RESPONSE TO DP&E REQUEST FOR ADDITIONAL INFORMATION - MOD 1 TO MP09_0146 EASTLAKES SHOPPING CENTRE

This letter has been prepared by Urbis on behalf of Stateland East Unit Trust (The Applicant) regarding MP09_0146 Mod 1 – Modification to Eastlakes Shopping Centre Mixed Use Development.

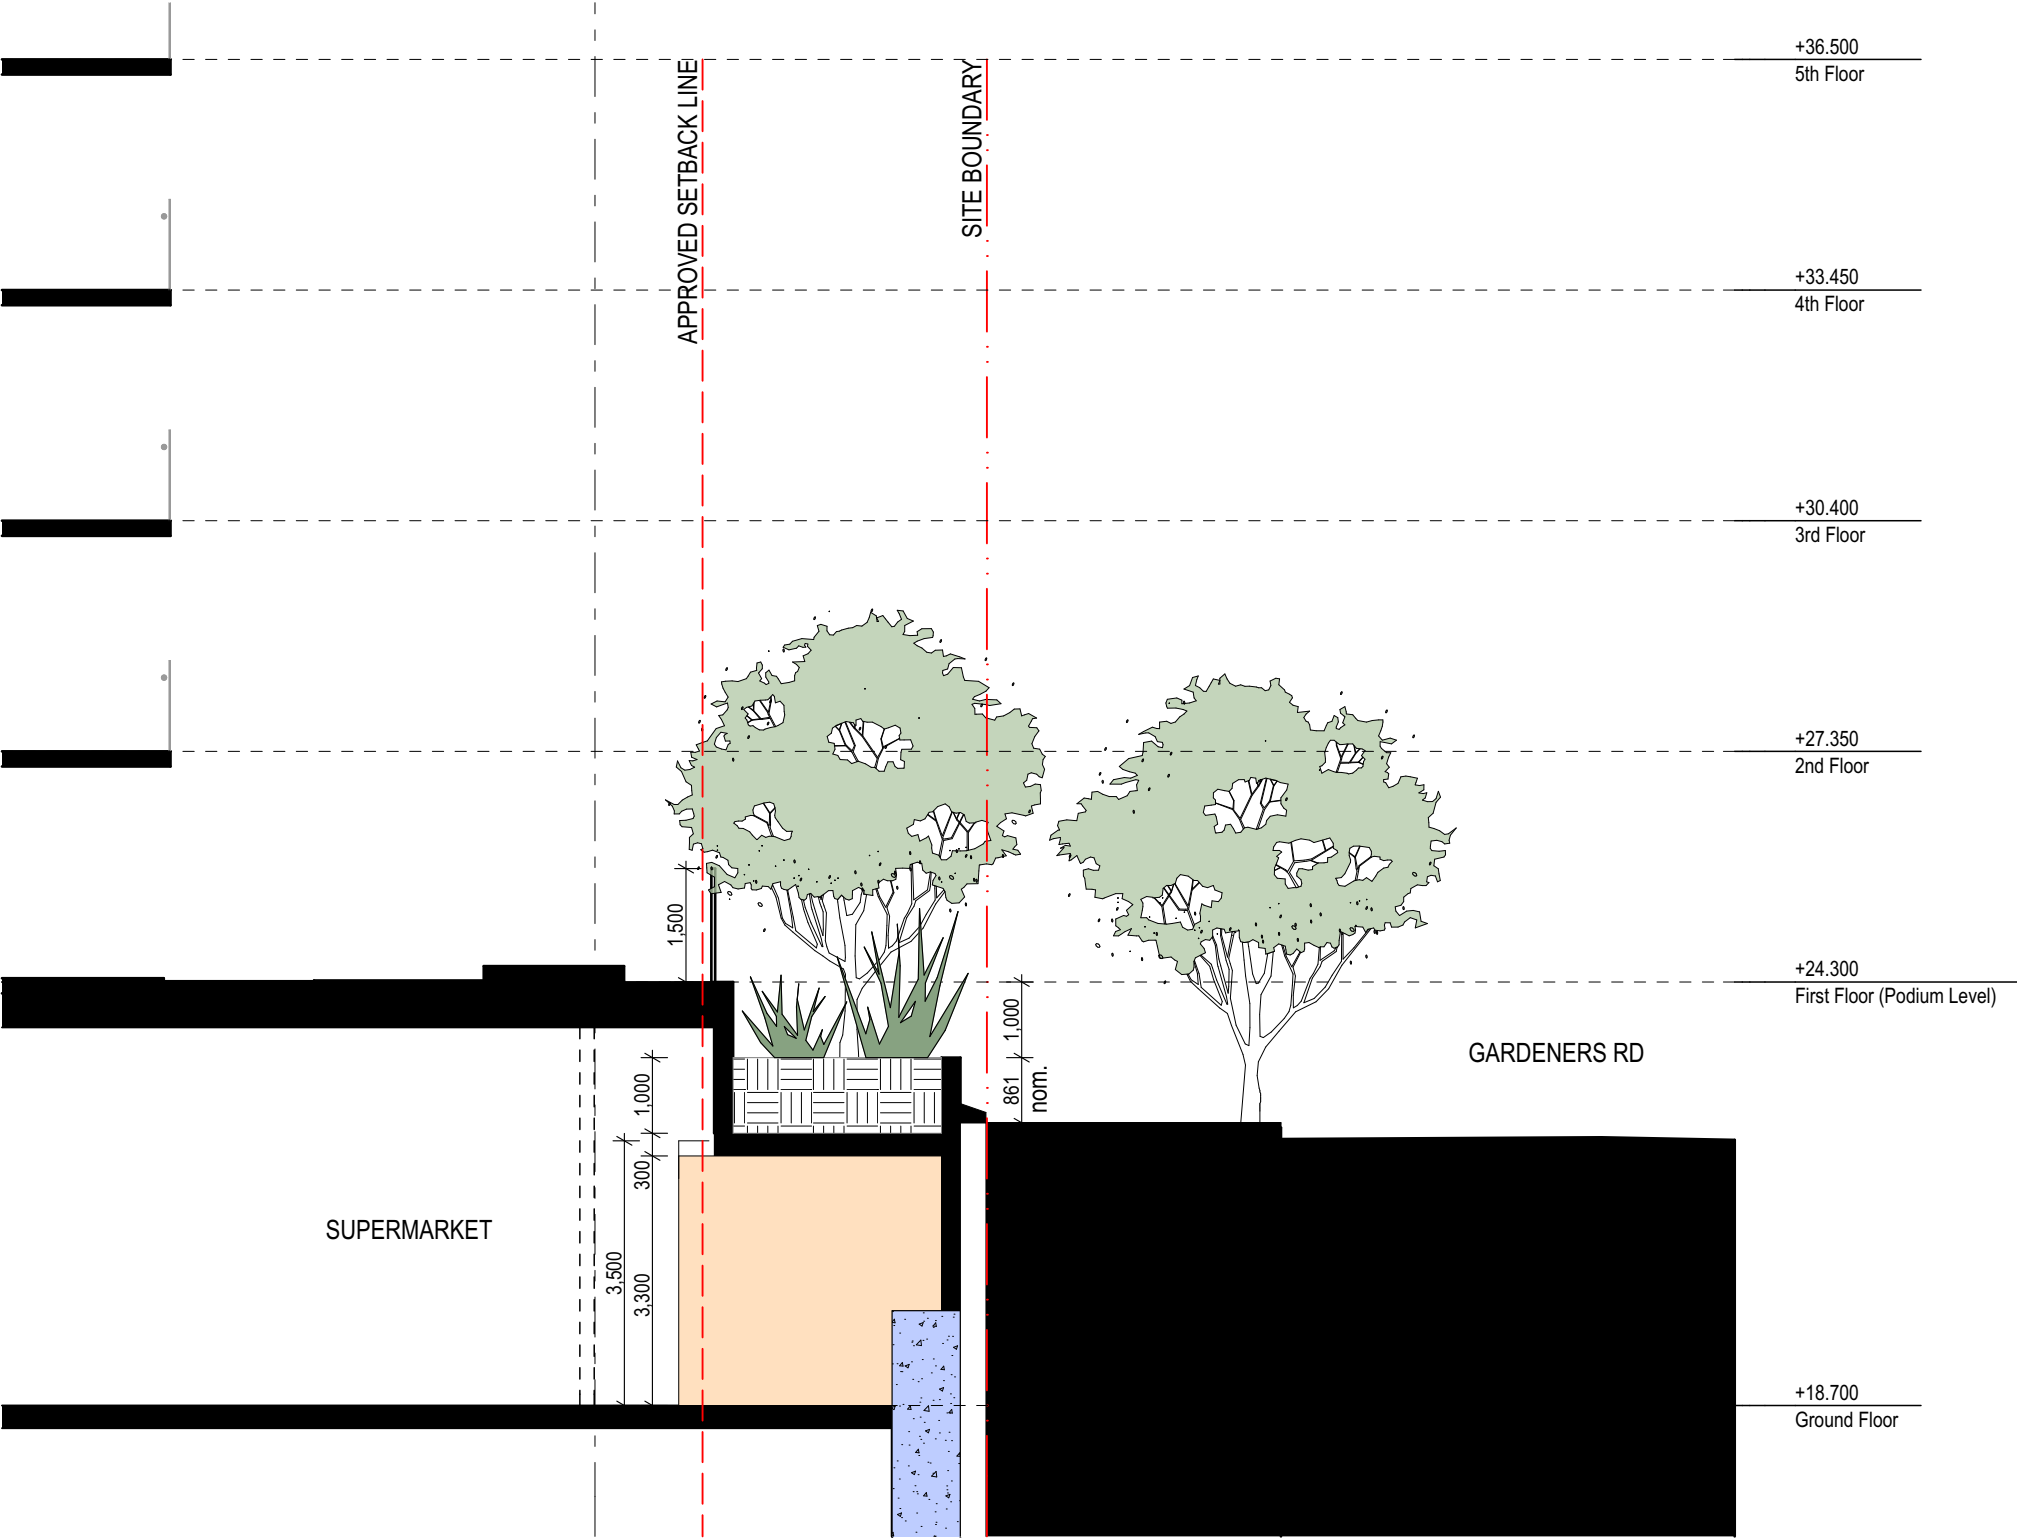
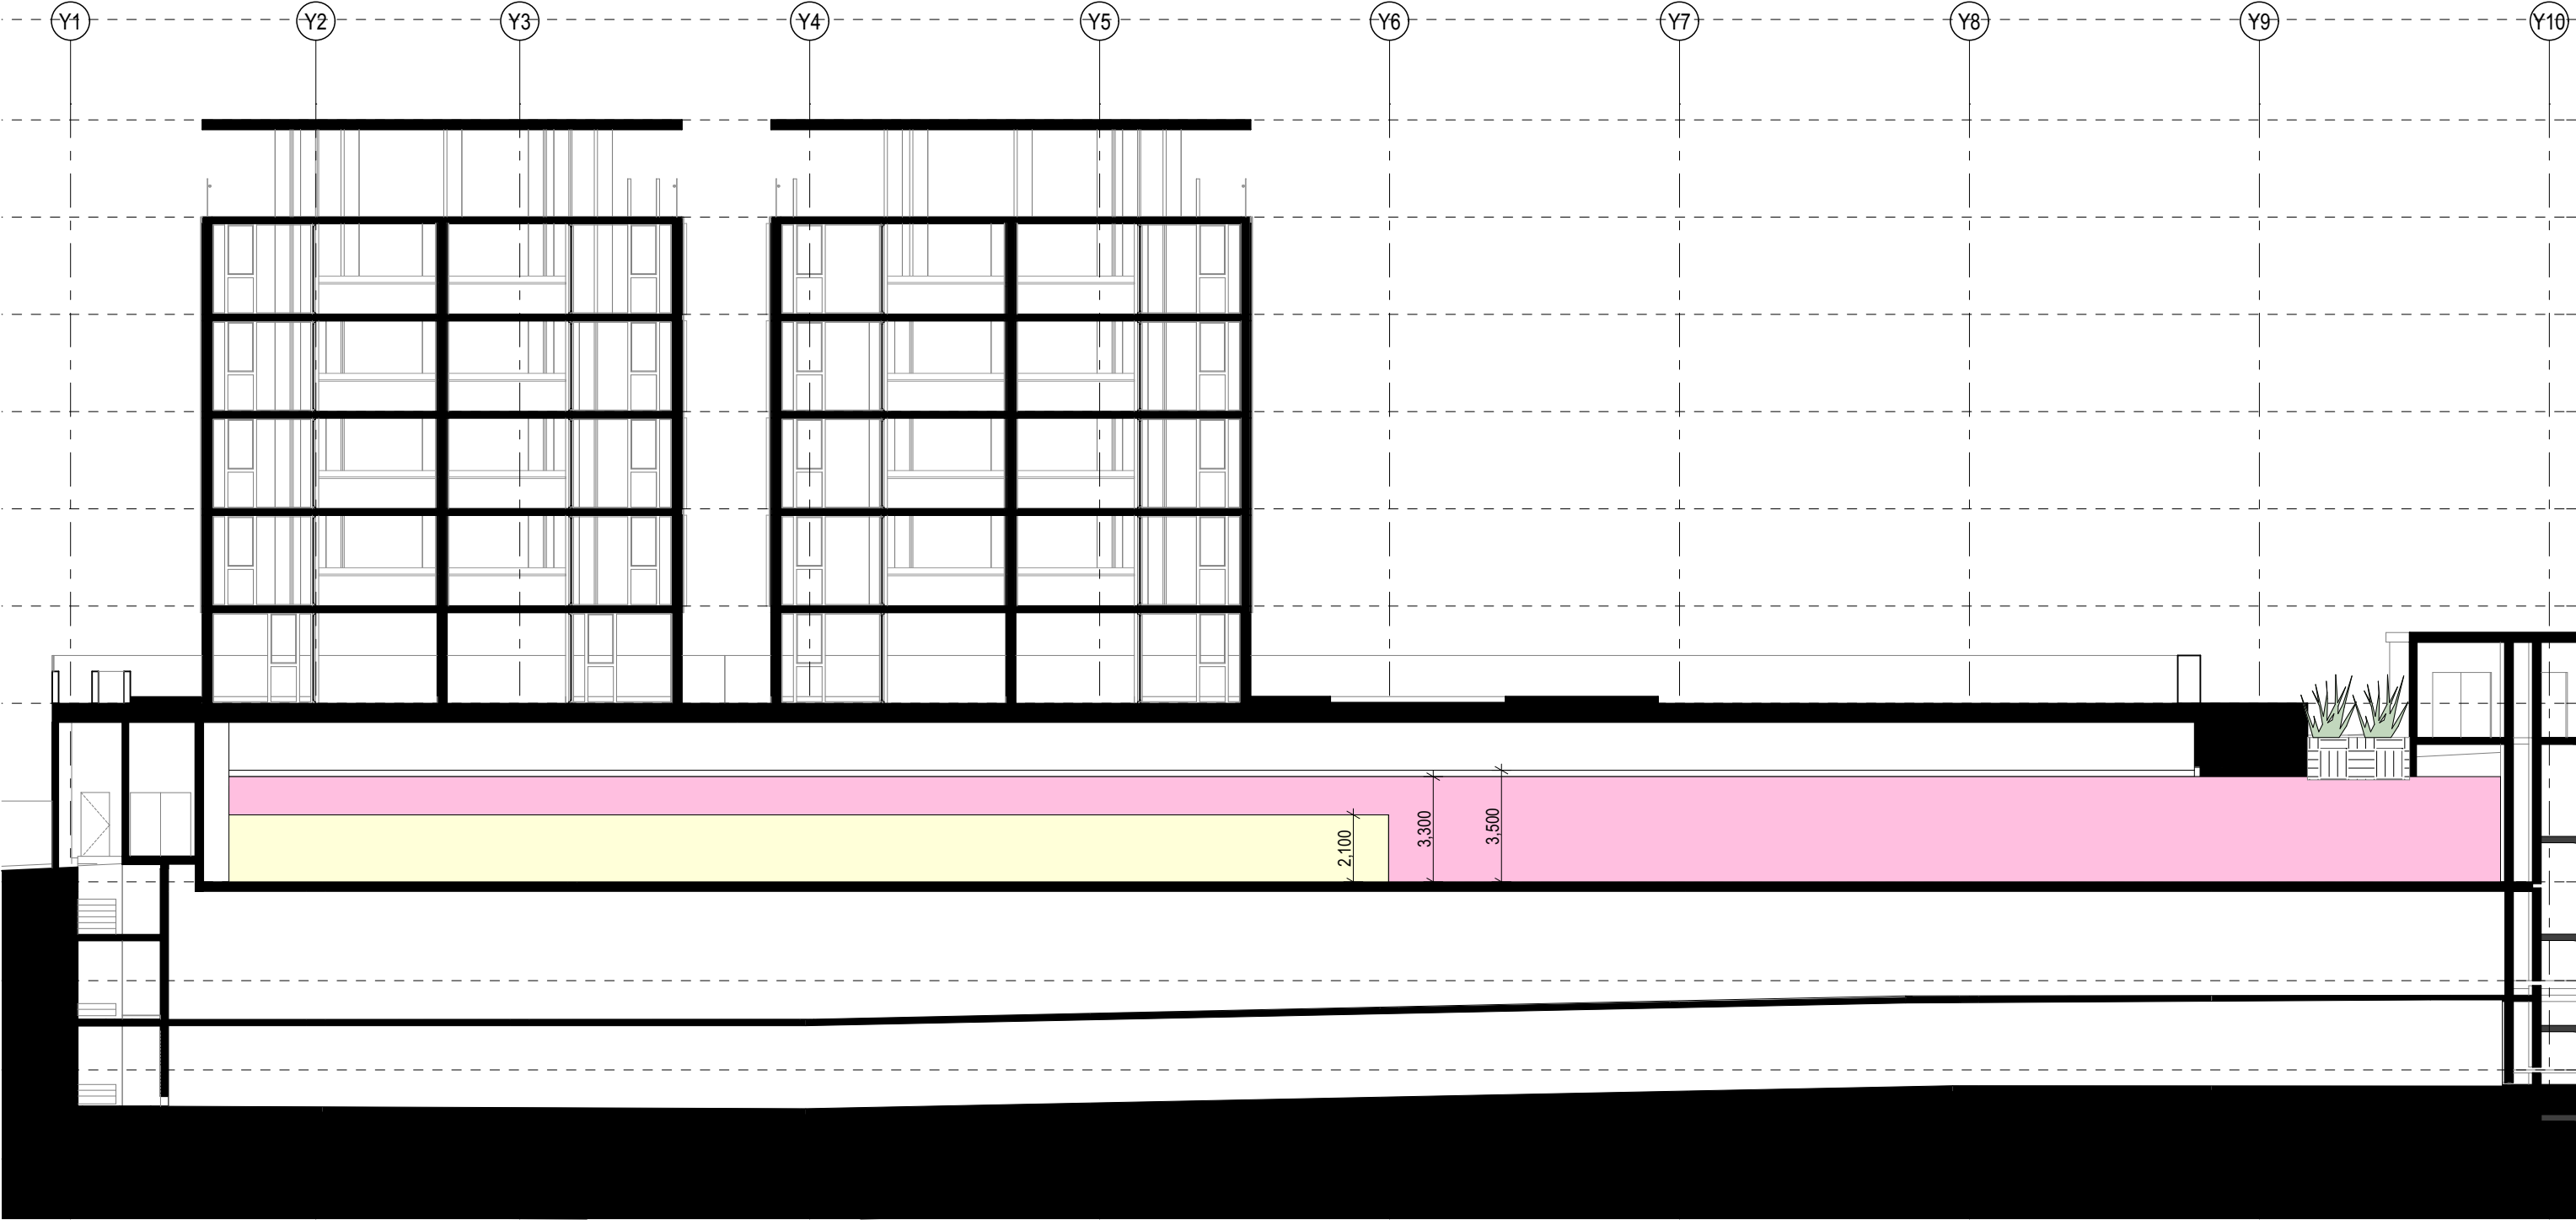
- **Western Elevation:** reinstate tree plantings along south-western setback at ground level to screen the wall behind.
- **Eastern Elevation:** increase landscaping to screen the 1.8m boundary wall.
- **Gardeners Road:** investigate ways to reduce the height of the 6m high 'unbroken' wall which results in an adverse urban design outcome.
- **Building 1B:** investigate reducing height of architectural roof feature.

A series of perspectives have been prepared by FJMT to assist with understanding the rationale behind the design of the architectural roof feature (see Appendix A).

In summary, the height of the roof feature is considered appropriate for the following reasons:

- It is largely open with glazed balustrades and feature external fins and does not read as an additional storey.
- The 'view through to the sky' helps to reduce the perceived mass of the building.
- From an architectural perspective, the taller proportion is more elegant.
- The parapet height along the eastern side conceals plant rooms and lift overrun which are otherwise unsightly when viewed from the public domain.
